Re: Mercer Island Transit Integration Project - Permits and Conveyances

SUBMITTAL REVIEW COMMENTS

AE 0072-19 Mercer Island Transit Interchange

Submittal No./Ref./Title: 90% Submittal Date Received: 9/18/2020

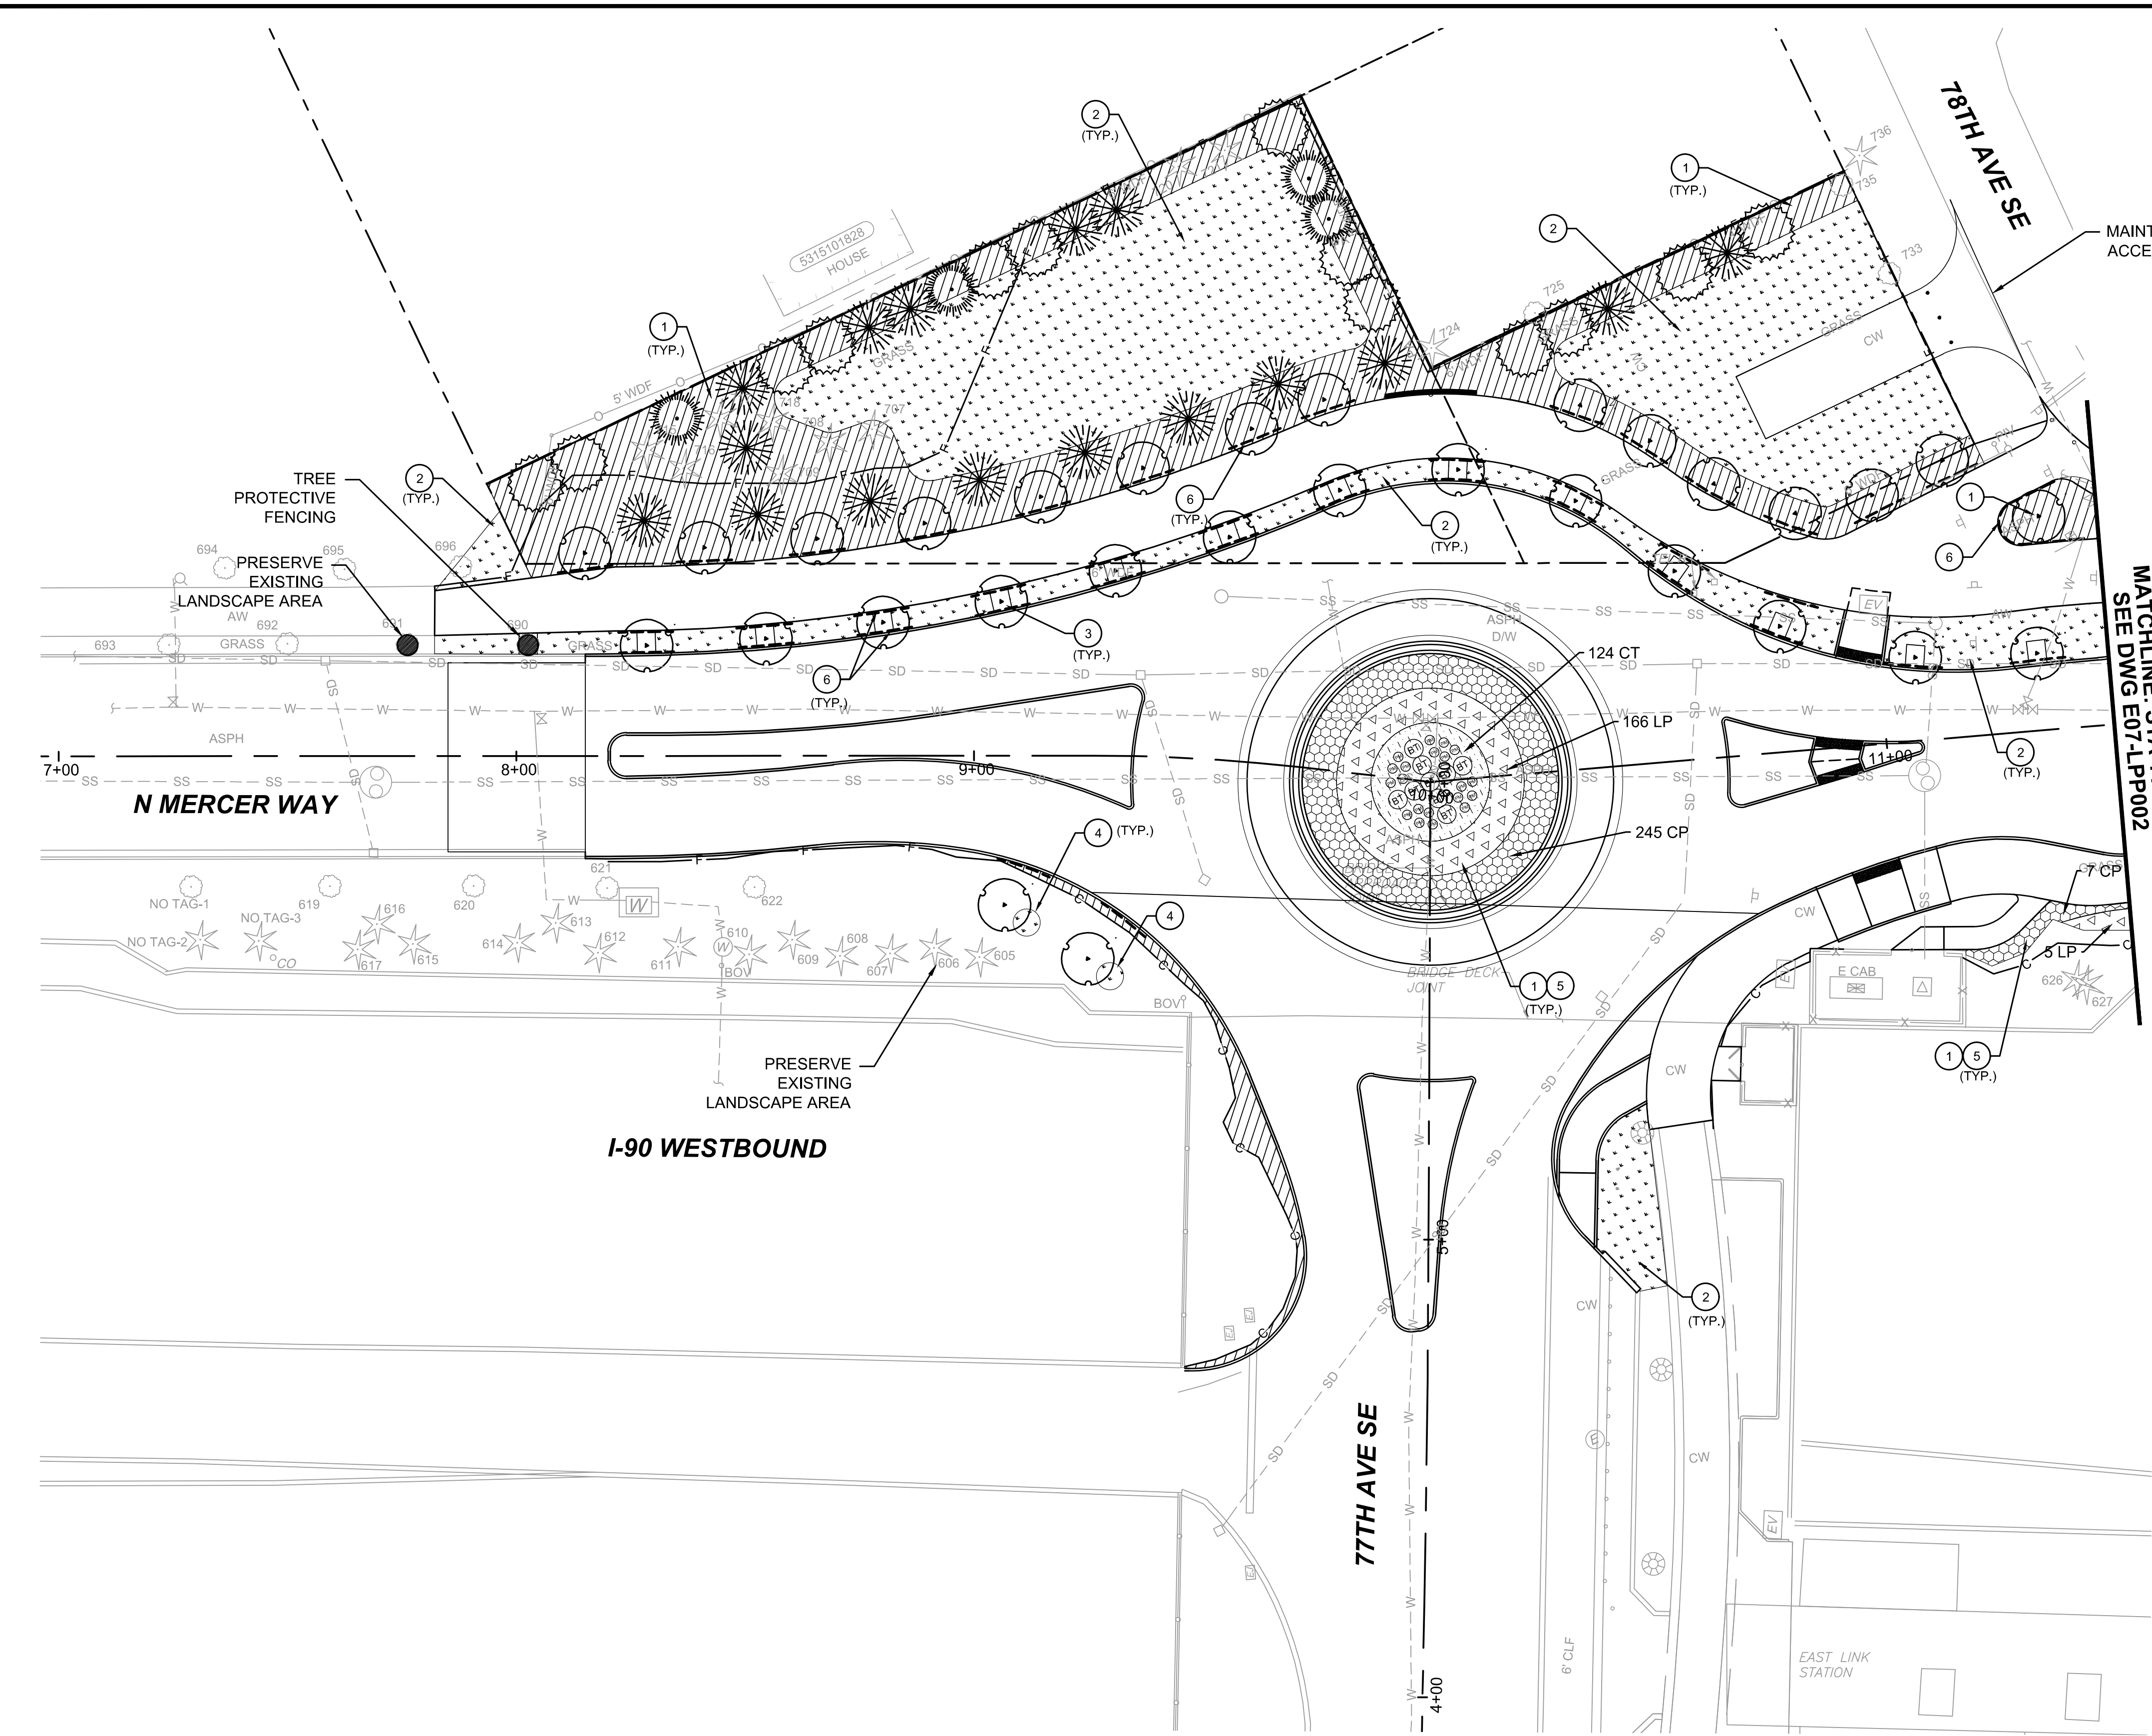
landscape plants to maintain their growth until irrigation is restored. Plants damaged from lack of water must be replaced by the contractor."		
PK 13	90% Plans	87	AS/P W	Remove trees 731 and 732 on 78 th for visibility to path. We do want some screening plantings here that do not block visibility between motorists and cyclists approaching this intersection.	Will do.	AD
PK 14	90% Plans	87	AS/P W	Bed between main trail and spur trail to 78 th /24 th . This bed is crowded with utilities. The dogwood will block sightlines. Substitute Persian Spire Parrotia. No groundcover, just mulch.	Will incorporate	AD
PK 15	90% Plans	87	AS/P W	Please no crushed gravel landscape surfacing on parcels. Gravel permanently compromises the soil media. Instead, we propose that the trees be in linear mulched beds, one along the path and the other along the fenceline. In between have lawn. If you are trying to save budget, we would suggest that no groundcovers are needed in mulched beds and lawn can be unirrigated.	Will do	AD

DRAWING No.:  
**E07-CRY002**  
LOCATION ID:  
E07  
SHEET No.:  
9 OF 104  
REV:  
0

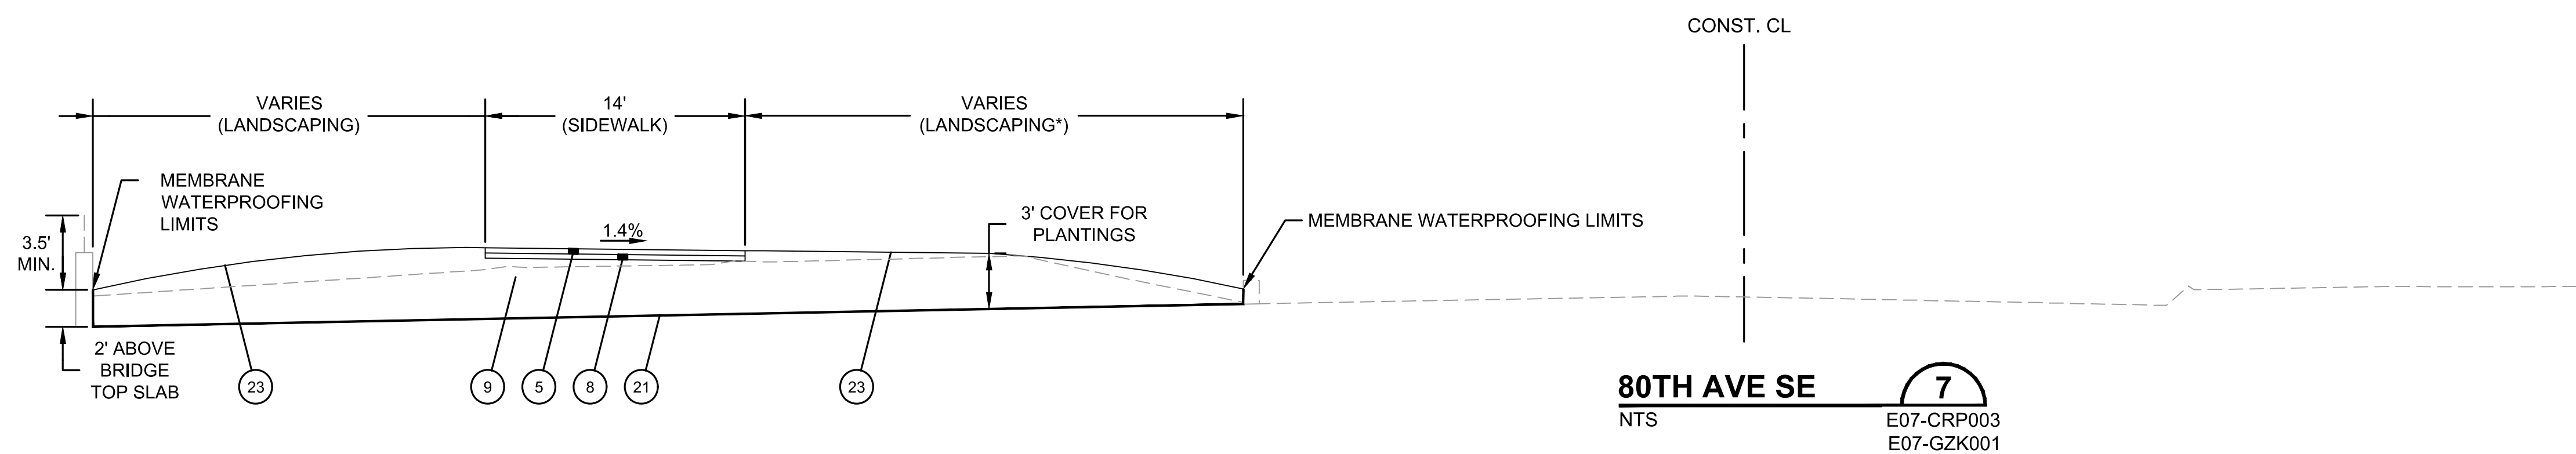
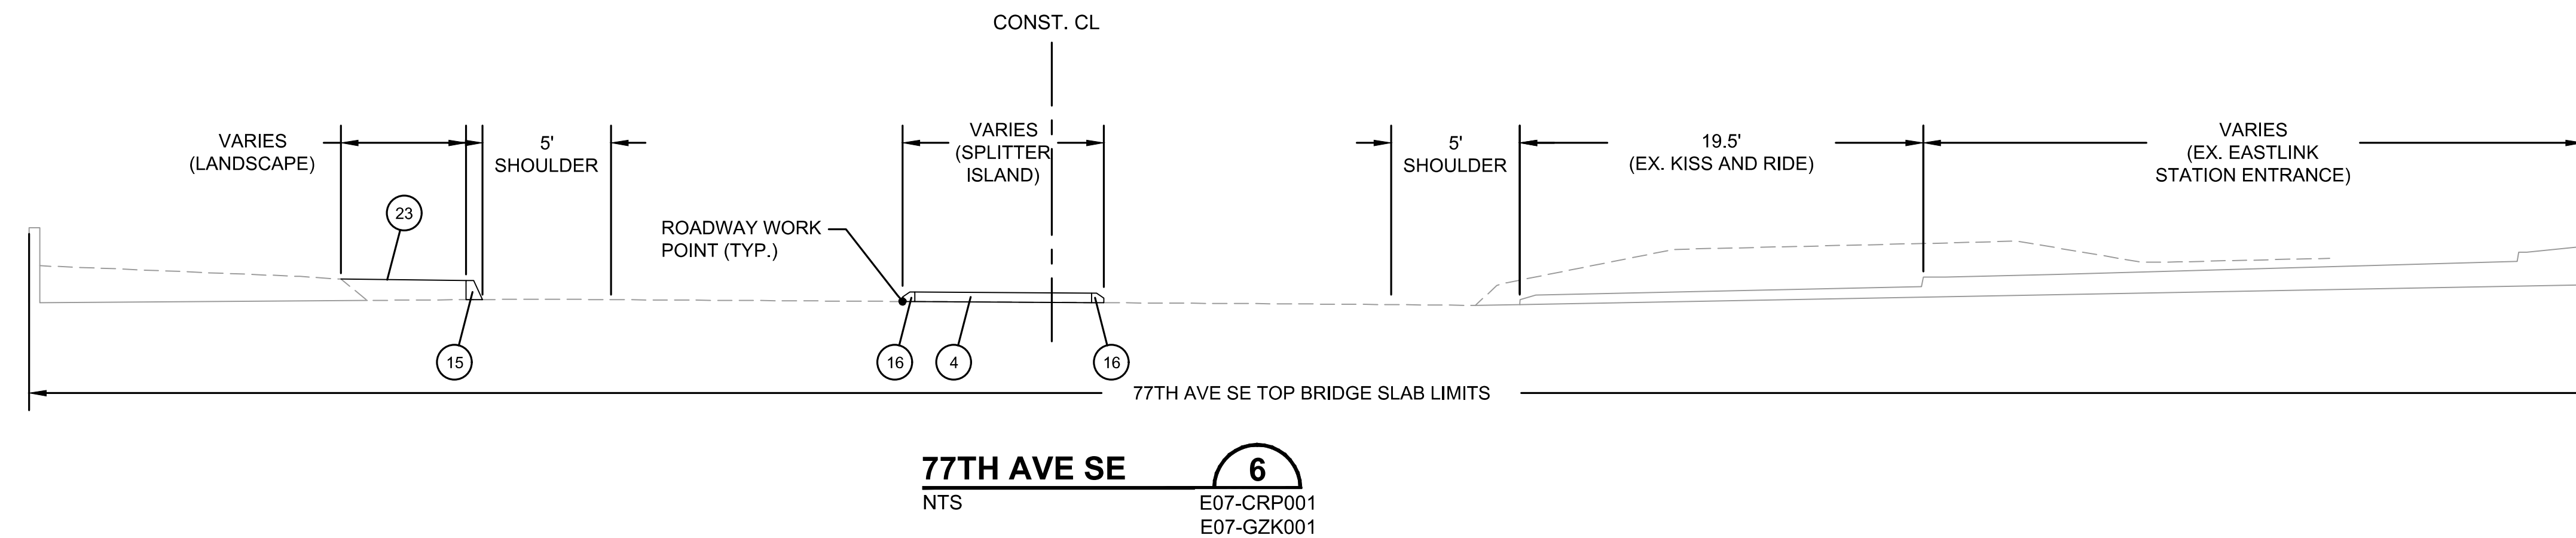
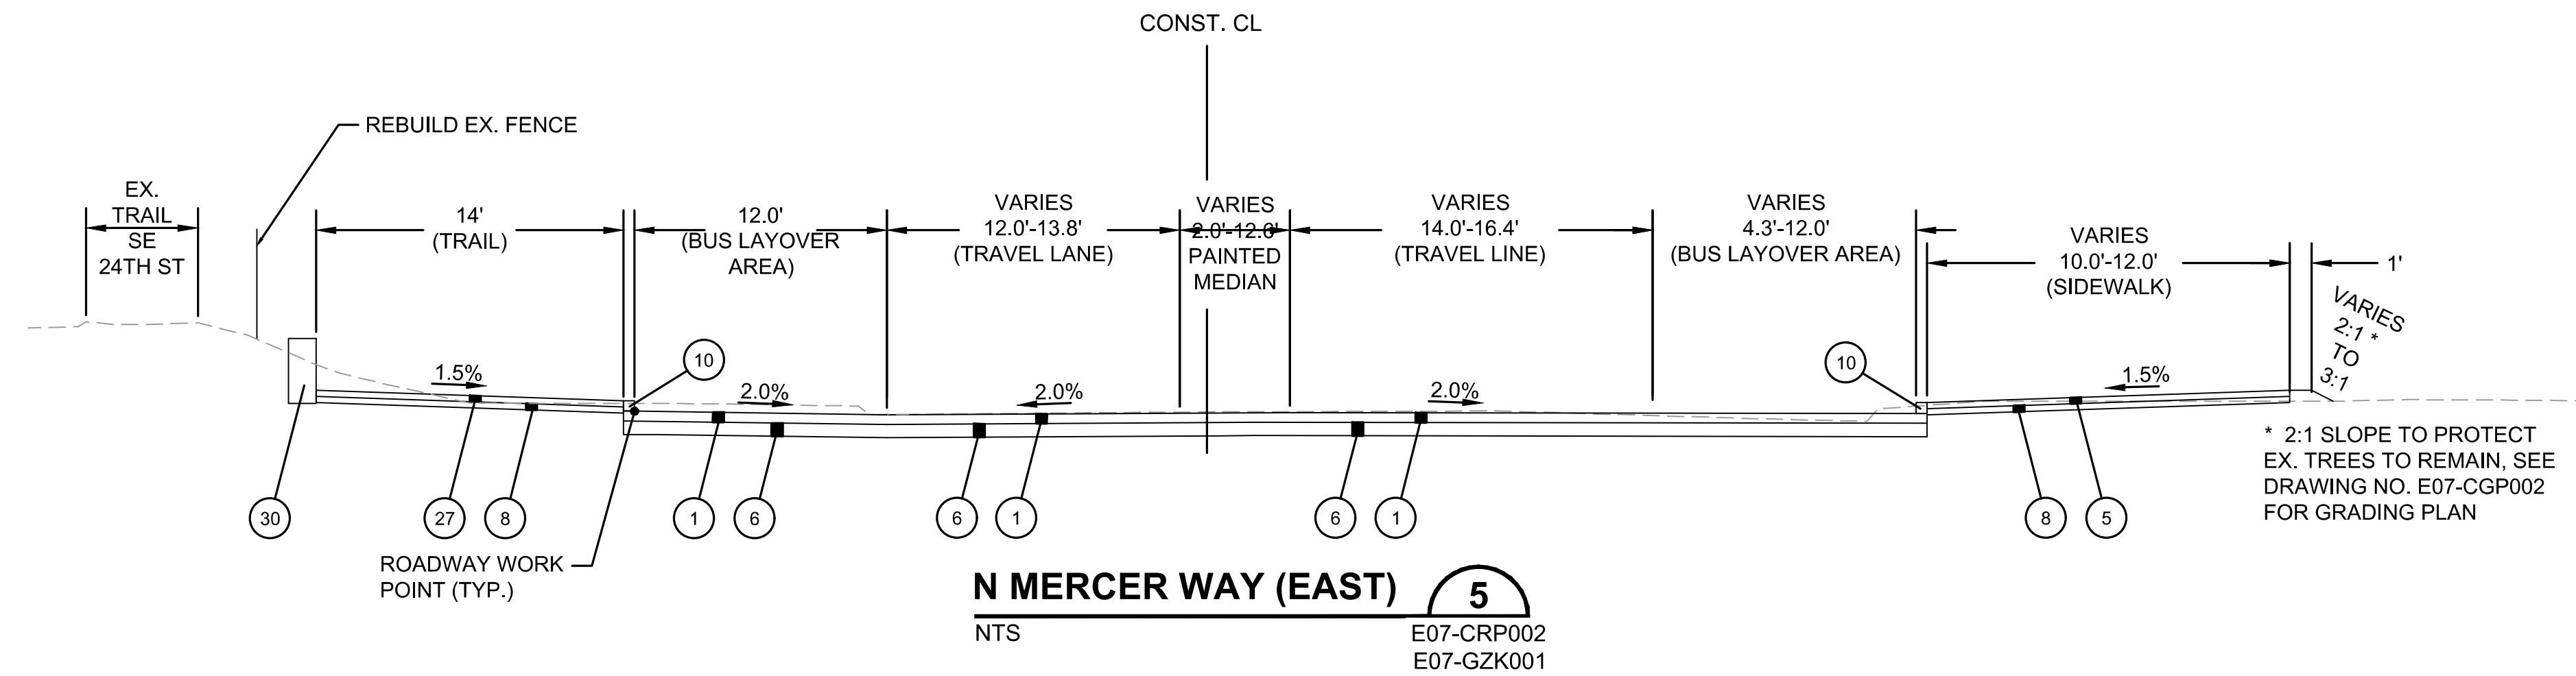
PW1	90% Plans	9/92 CRY002	TRF	60% - PW 5 comment has not been addressed in the 90% design. The plan views (e.g. CMP001) correctly shows the west side (southbound) bike lane on 77th Ave SE. Revise cross-section to be consistent with the plan view.	Will revise.	AD
PW2	90% Plans	12/96 CXP002	TRF	60% - PW 6 comment has not been addressed in the 90% design. Include in the site prep a note to remove the FH at approx. sta 11+52 north side. Since FH relocation is noted on utility plan, add note to Site Prep to relocate per UCP001.	Utilities are not within site prep/Demo plans. General note references UCP sheets for utility relocations, which include fire hydrant notes.	No Change
PW3	90% Plans	13/96 CXP003	TRF	Site prep note for 17 is missing or labels should be numbered 3.	Revised.	AD
PW4	90% Plans	15/96- 16/96 CTP001	TRF	60% - PW 9 comment has not been addressed in the 90% design. Add inlet protect for other CBs just outside the 'project limit' but potentially impacted by runoff. These include: <ul style="list-style-type: none"> • 80th Ave SE at 4+75 LT on east side. • 77th Ave SE within 'kiss-n-ride' • 77th Ave SE at 4+40 on west side near ramp. 	<ul style="list-style-type: none"> • Lid slopes towards west side on 80th so structure on east side is "uphill". • Do not see CB here- jbox? • Structure is in landscaped area outside of project limits – no need as no work in this planter area. 	AD
